Notice of Exhibition of application for Parramatta Metro - Over Station Development (SSD-35538829)

As delegate of the Heritage Council of NSW, I provide the following comments:

1.3 Massing Envelope

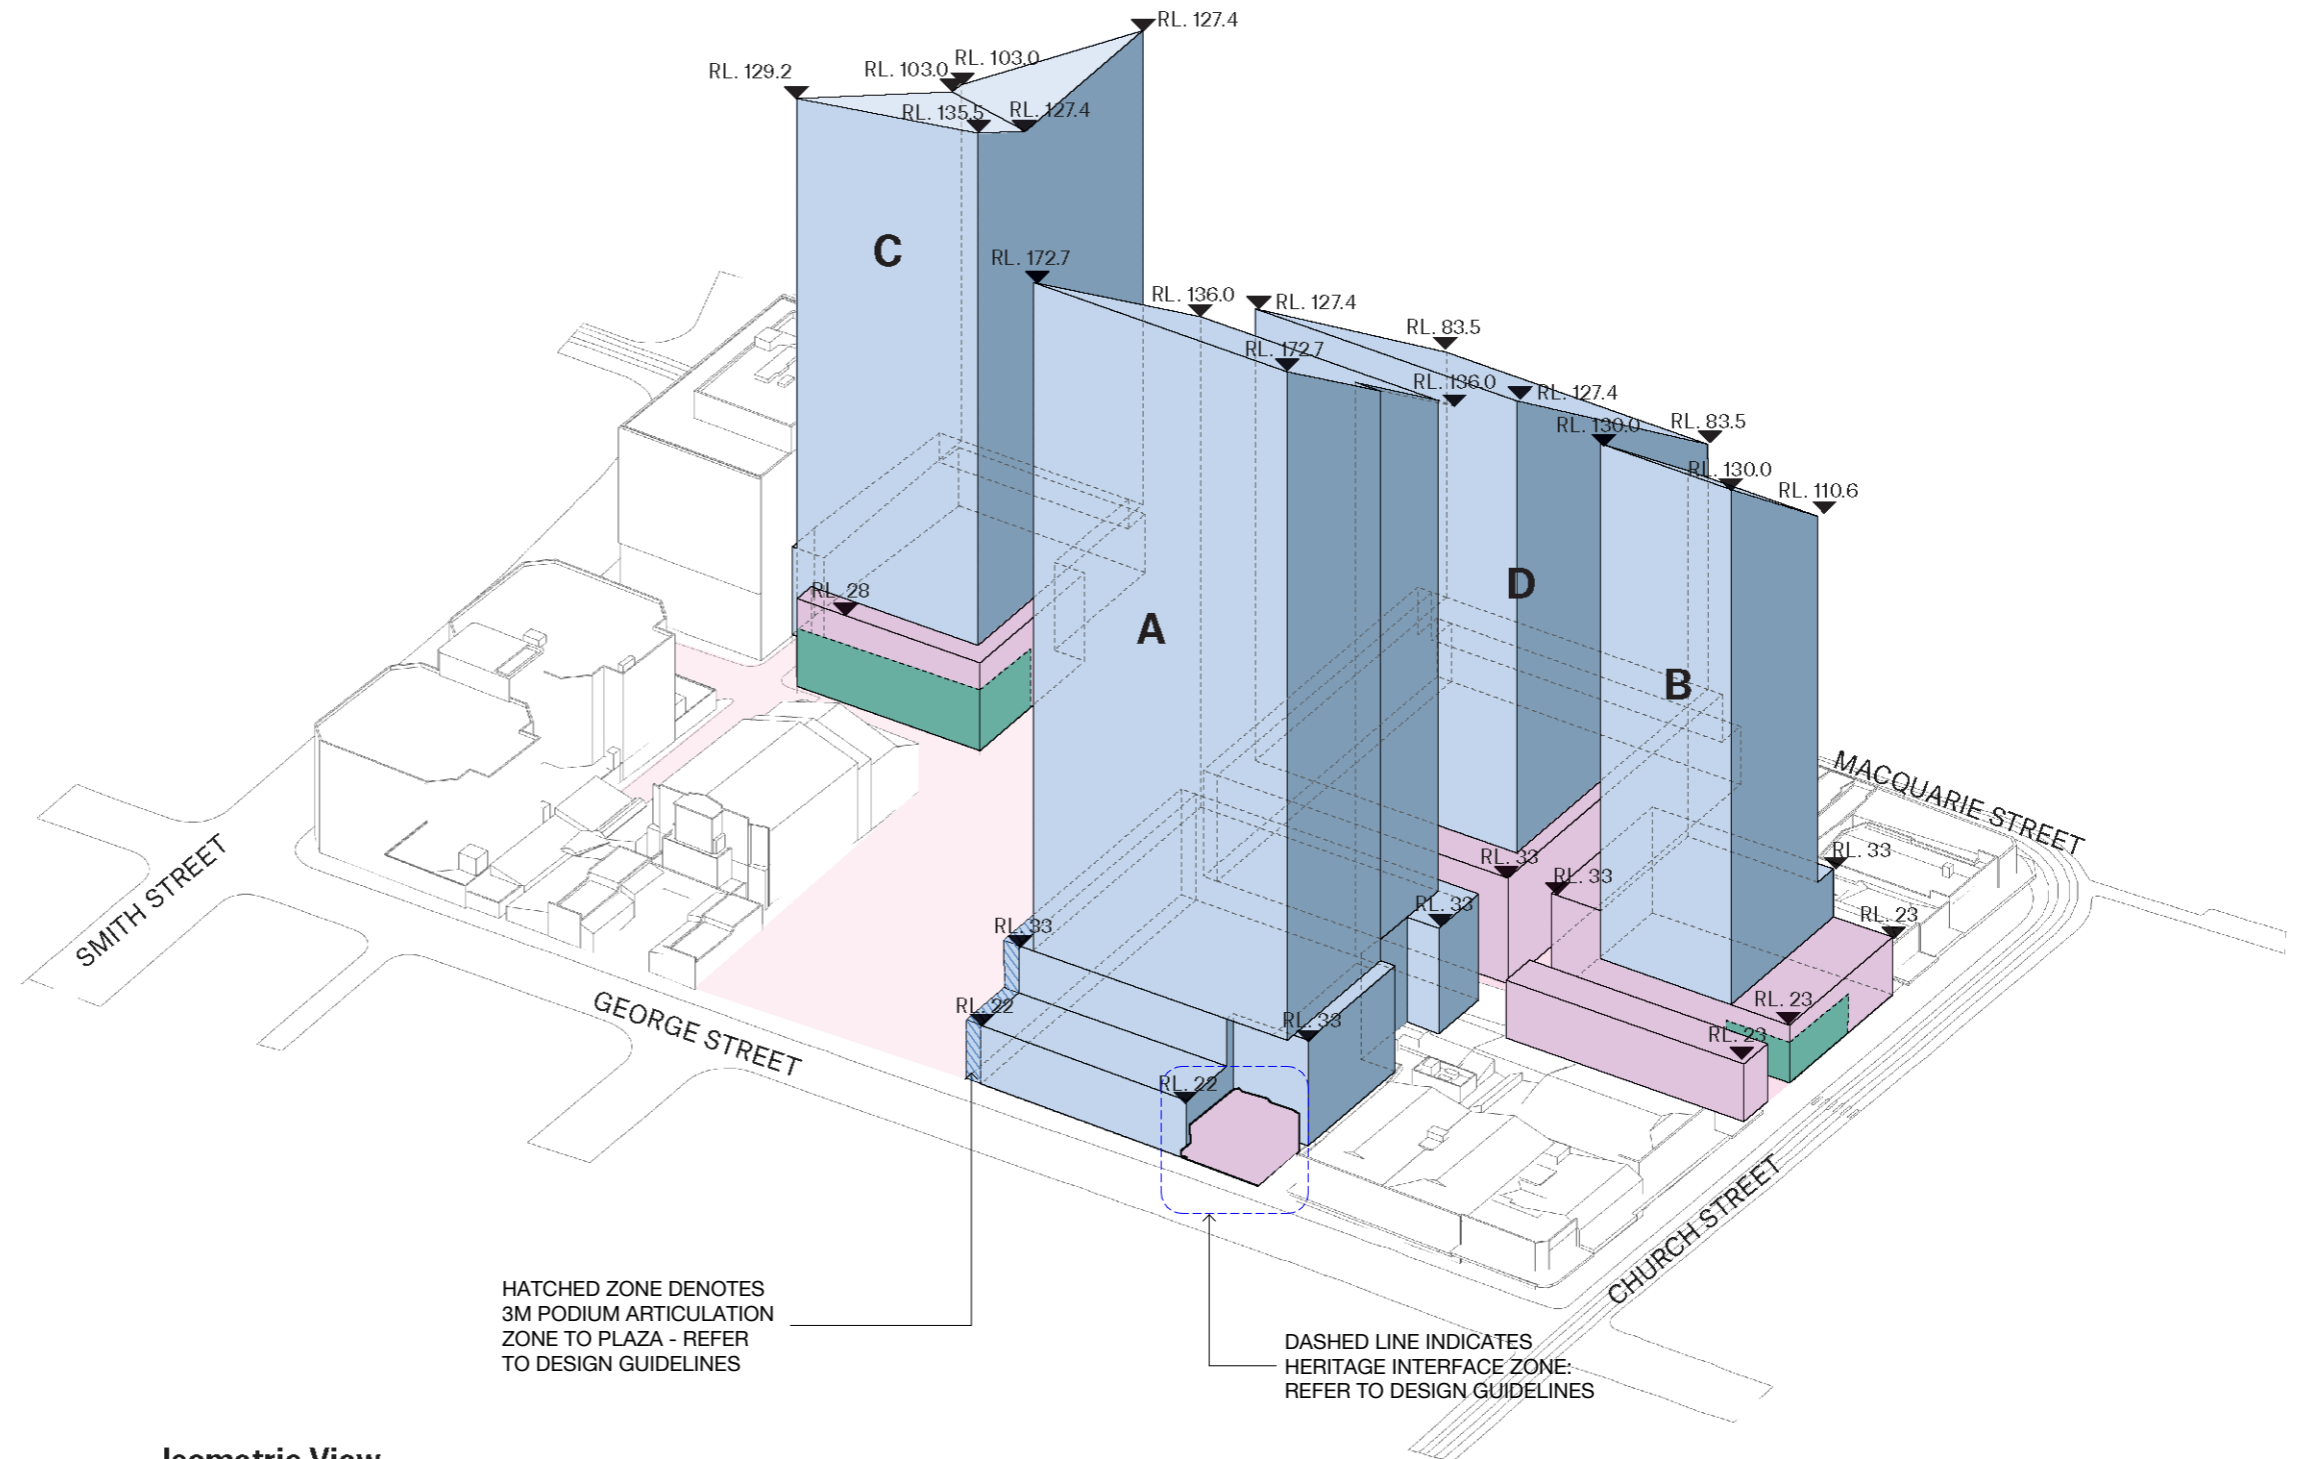
2. As this application deals only with building envelopes, it is noted that it does not include details around the interface between the various heritage items (for example local heritage item I703 (Shops and potential archaeological site at 41-59 George Street). Section 3.0 of the *Design Quality Guideline* is noted and strongly supported. These details in the guideline will be critical to the successful and sympathetic integration of the proposed new elements and the existing heritage items. The application of the guidelines will be considered in detail when the future application is submitted.

3. The proposed public open space and “civic spine” is generally acceptable. It is understood that there will be an impact to the context of “Kia Ora” (local item I716, 62-64 Macquarie Street) and therefore an impact to the significance of the item. While this is regrettable, the northern end of the public open space has the potential to positively impact on the Roxy Theatre. The public open space will provide expanded views to the Roxy Theatre and may become a key focal point for that area of George Street. Even though the Roxy Theatre is outside the project site, consideration should be given to expanding the Heritage Design Guidelines component of the *Design Quality Guidelines* to include details and recommendations on the interface with it.
